**RFI**

**RFI #: 99**  
**Date:** 4/3/2012  
**Job:** EB-02 Keller Springs Lofts  
**Phone:** 877-777-5115

**Subject:** B1 HC Unit Differences - Structural vs Architectural

**RFI #: 98**  
**Date:** 3/29/2012  
**Job:** EB-02 Keller Springs Lofts  
**Phone:** 877-777-5115

2.6HC

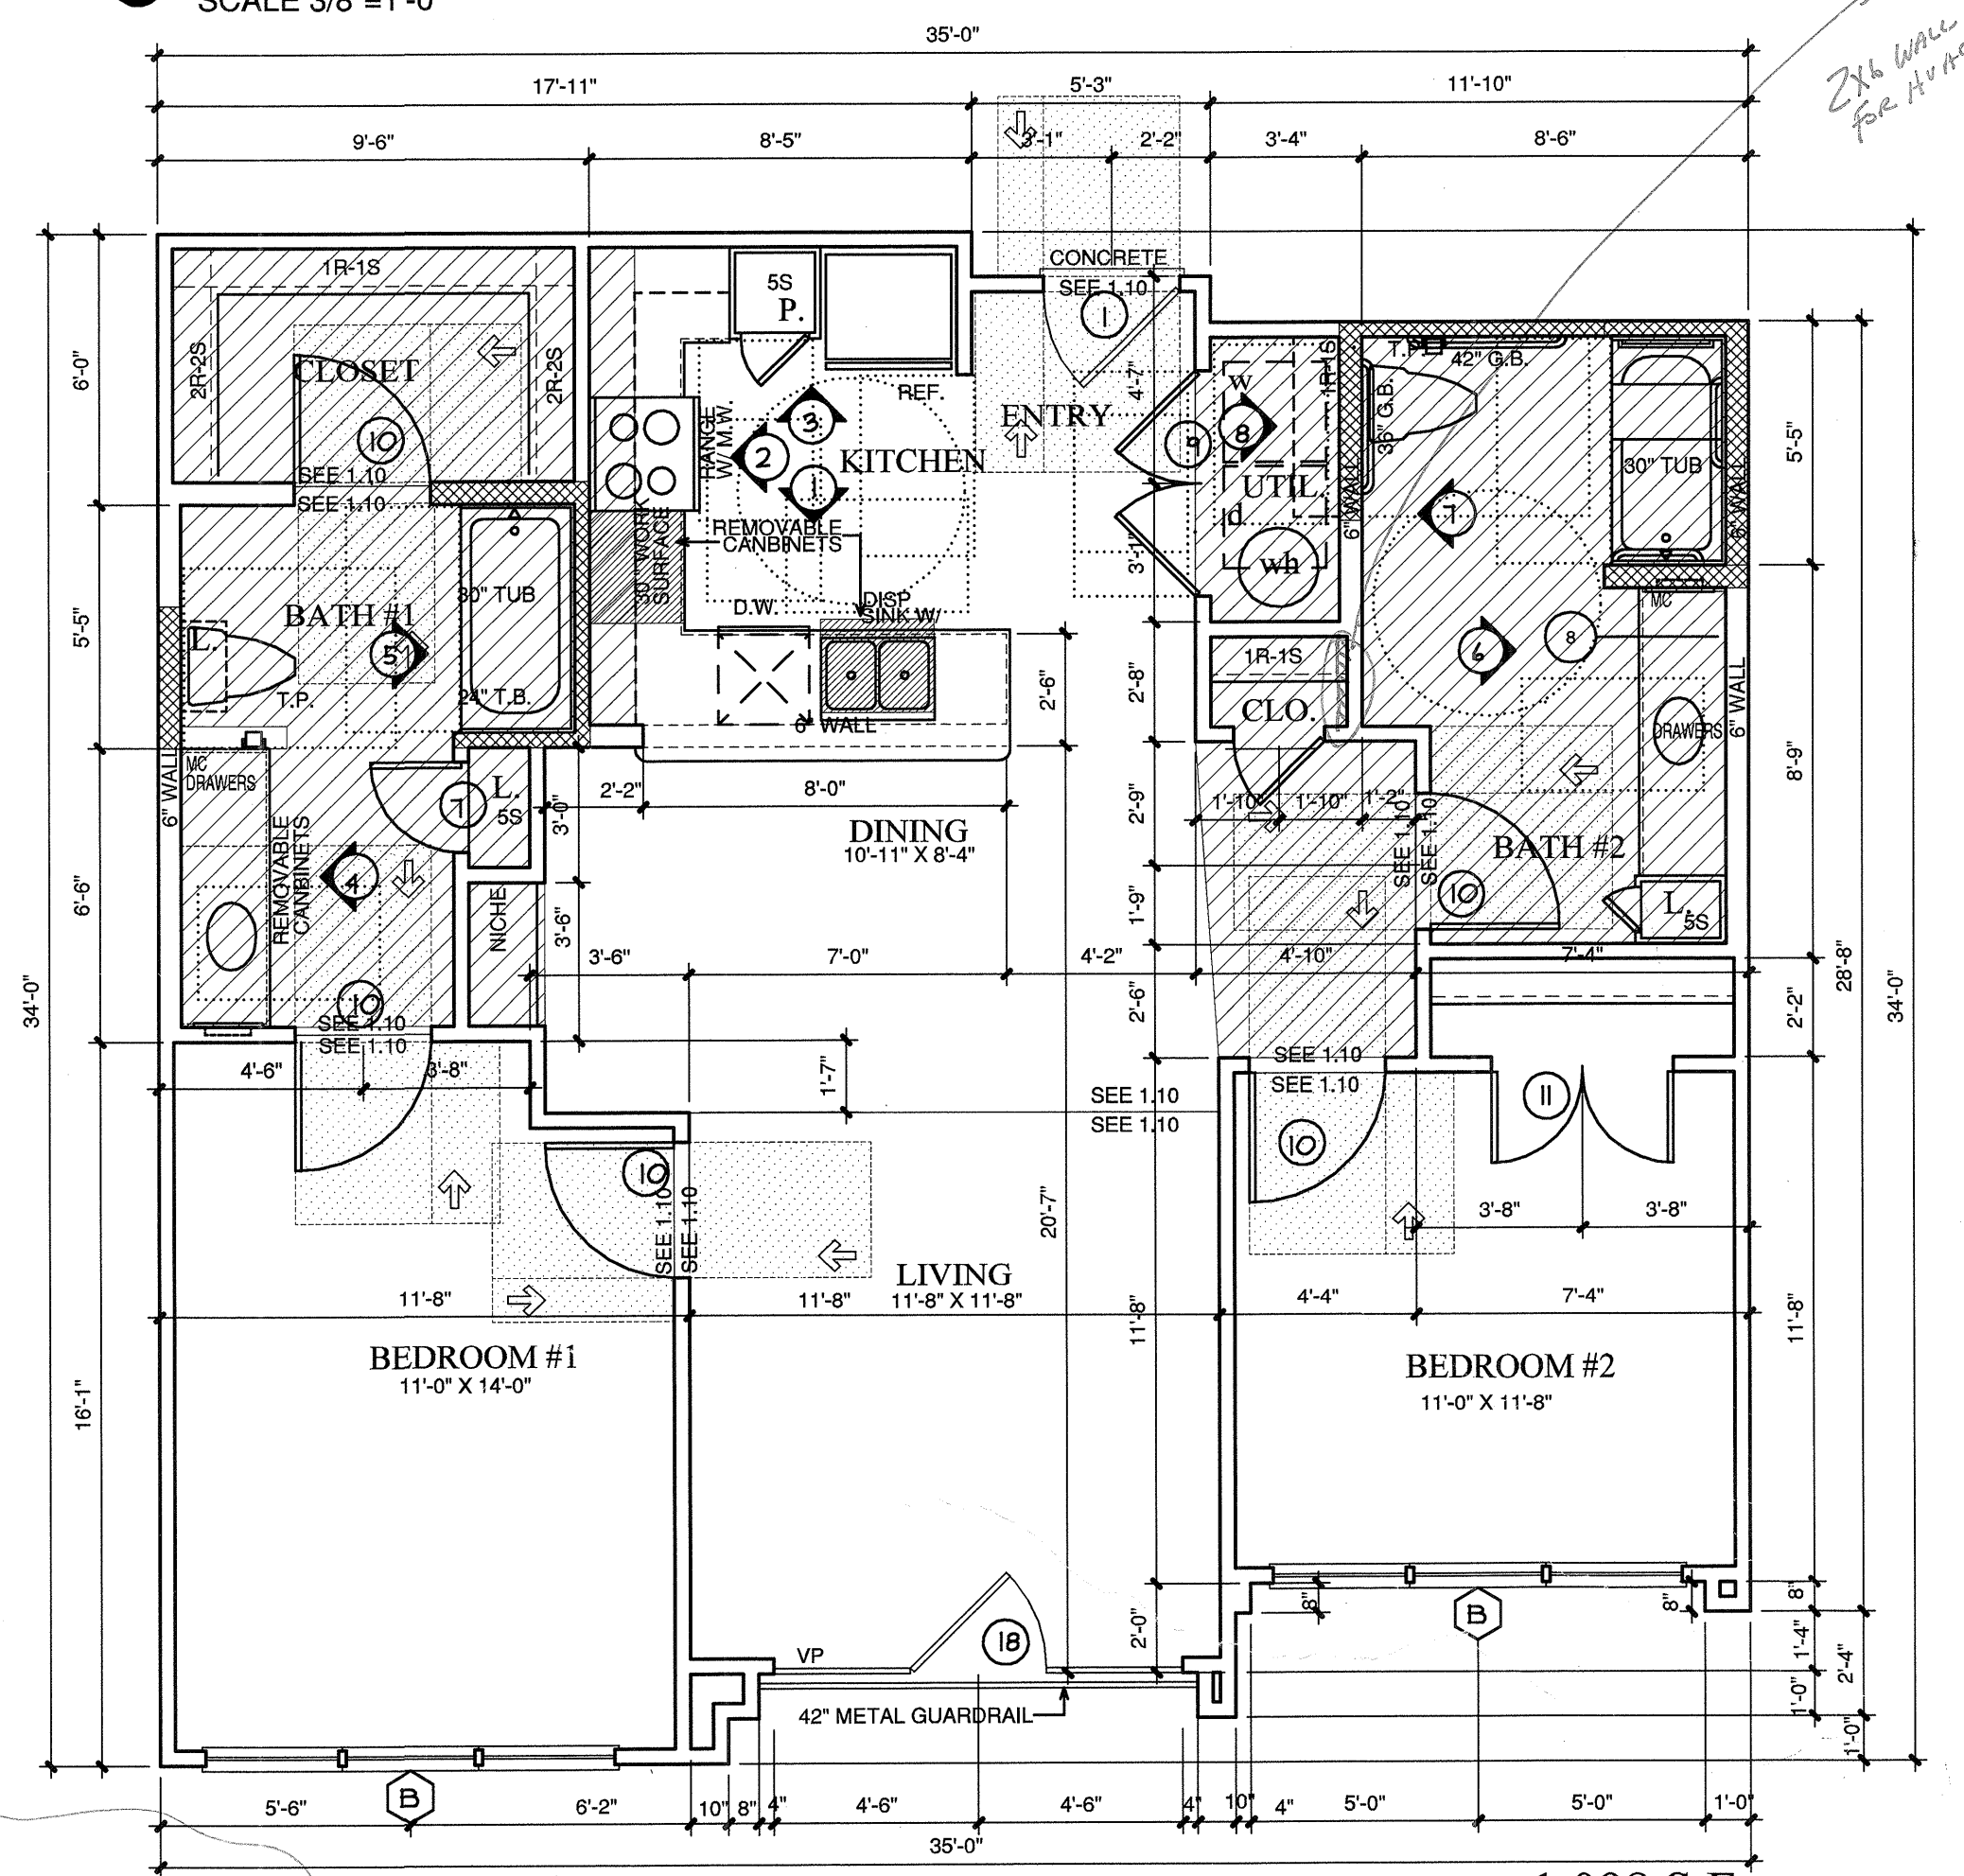
**Request:** 1/S2.05 shows different wall locations than the unit shown on A2.6HC. Please confirm which is correct and make revisions. **Date Required:** 4/11/2012

**Request:** The floorplan shown for the B1HC unit on S2.5 is different from the floorplan shown on A2.6HC. Please let us know which is correct. **Date Required:** 4/6/2012

The Architecture is correct. Please see the attached sheet S2.05 that has been revised accordingly.

Architectural Drawings take precedent. Please verify with BGO that A2.6HC is correct.
